**Planning Application No: 3/2026/0298**

**Proposal: Proposed demolition of existing side extension and replacement with new single-storey side extension. Existing garage to be altered internally and externally to create first floor annex accommodation.**

**Location: New Laithe Lower Chapel Lane Grindleton BB7 4RN**

2 PROPOSED SITE PLAN
1 : 150

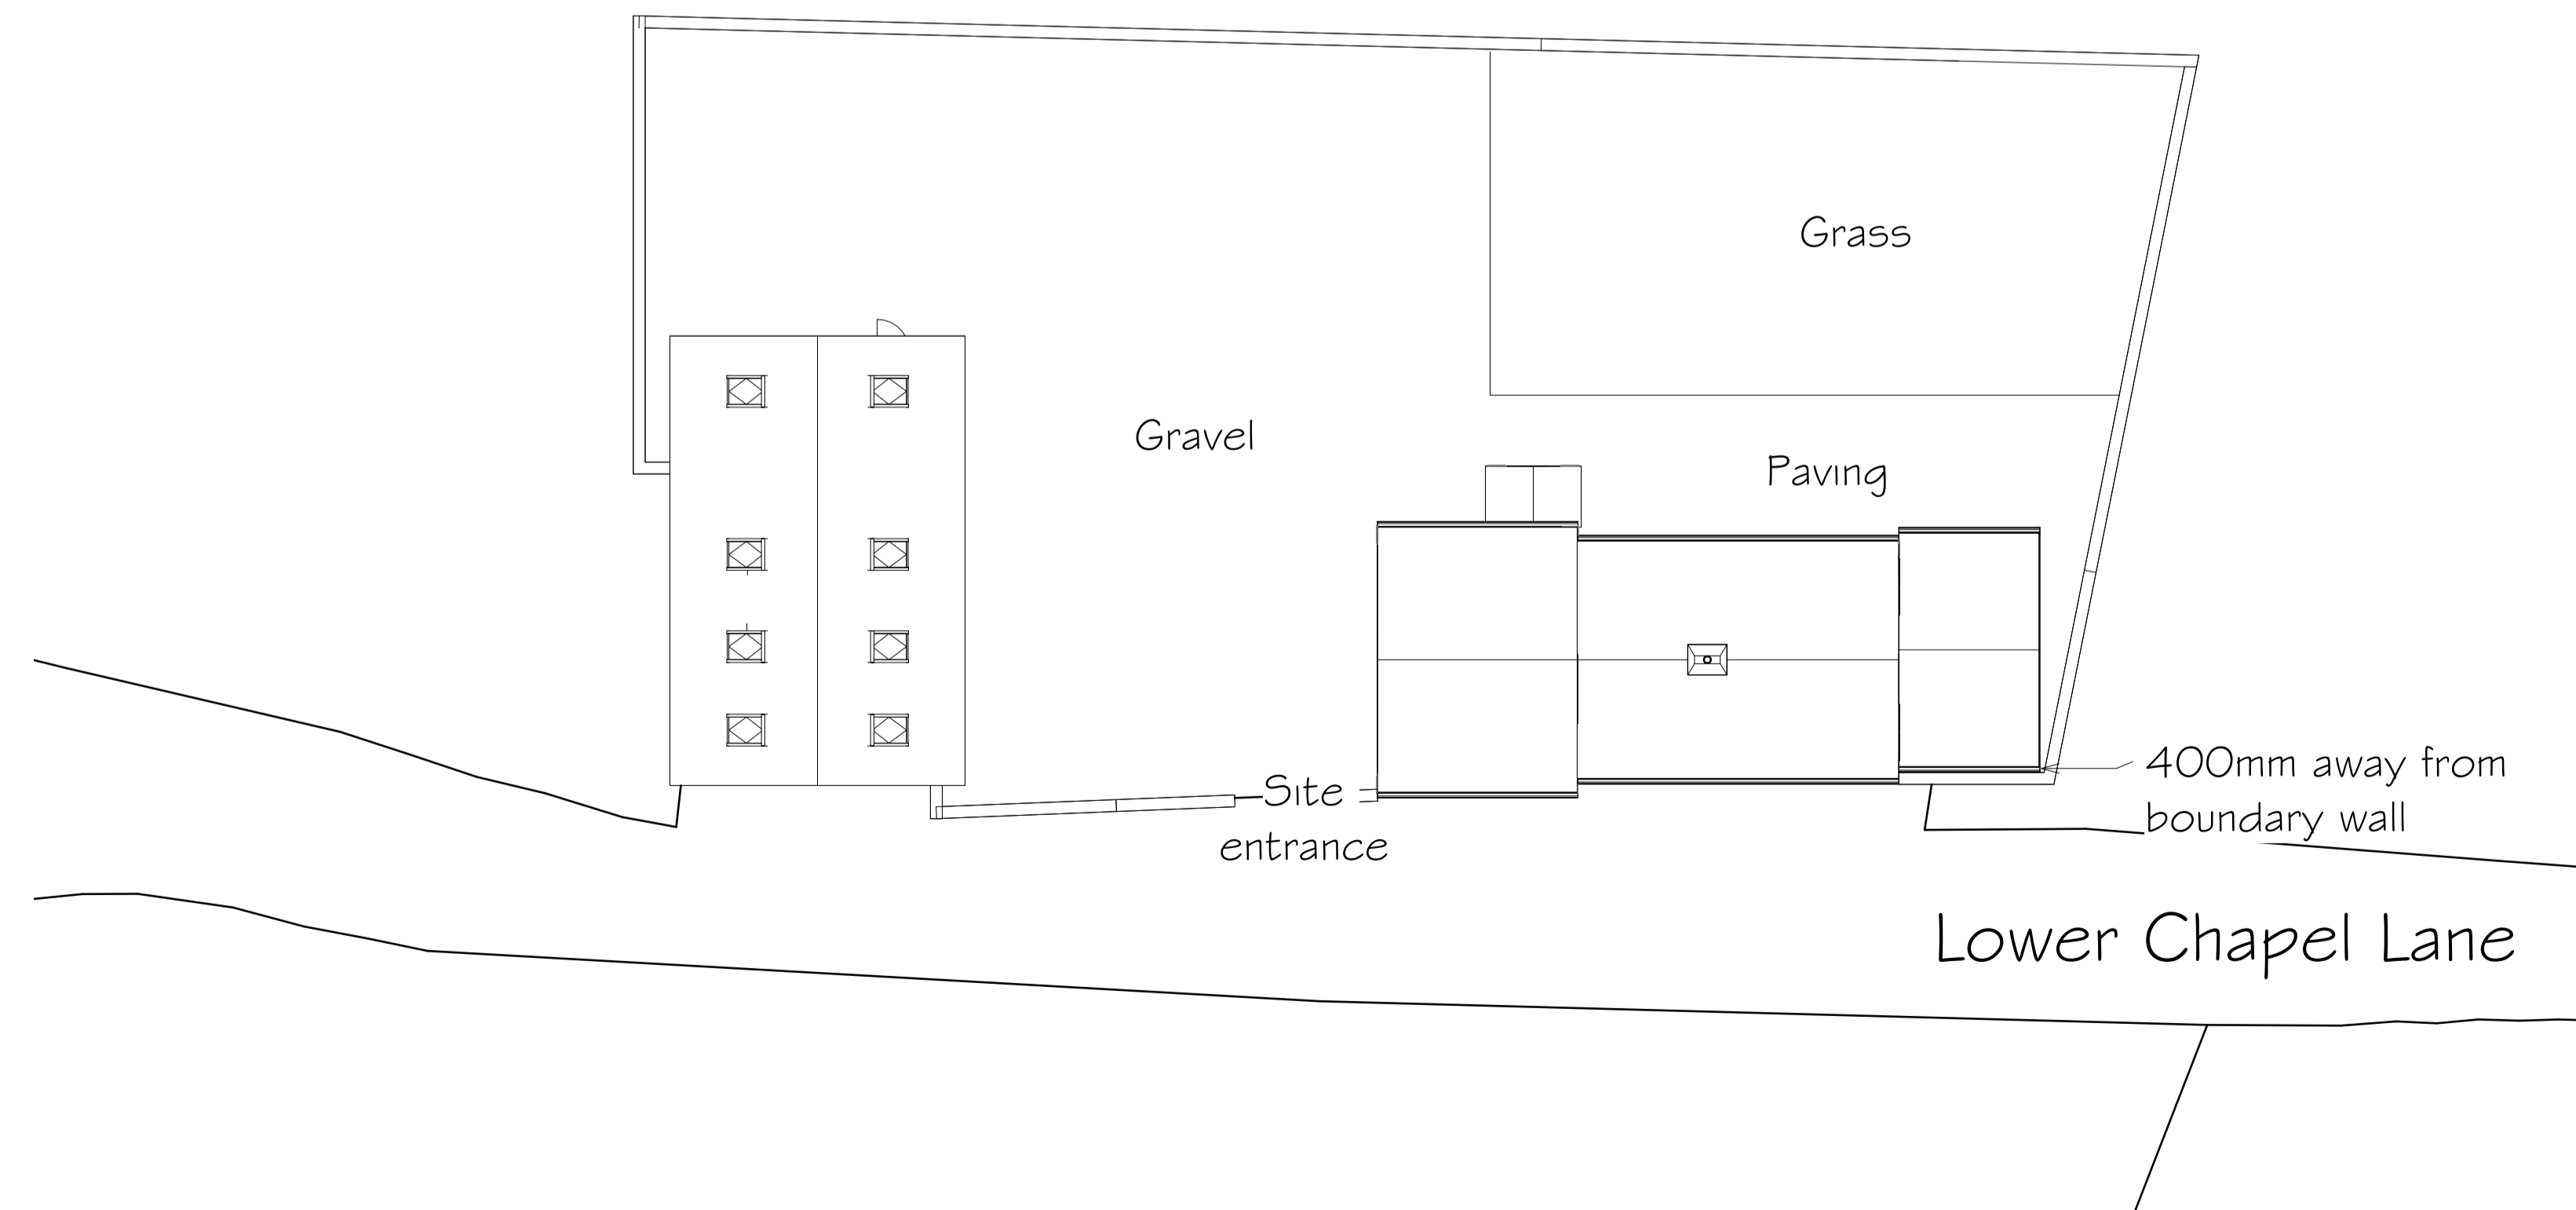
As the proposal is for annexe accommodation above the garage with one bedroom, it is recommended that a minimum of 1 bicycle space is provided for the proposal.
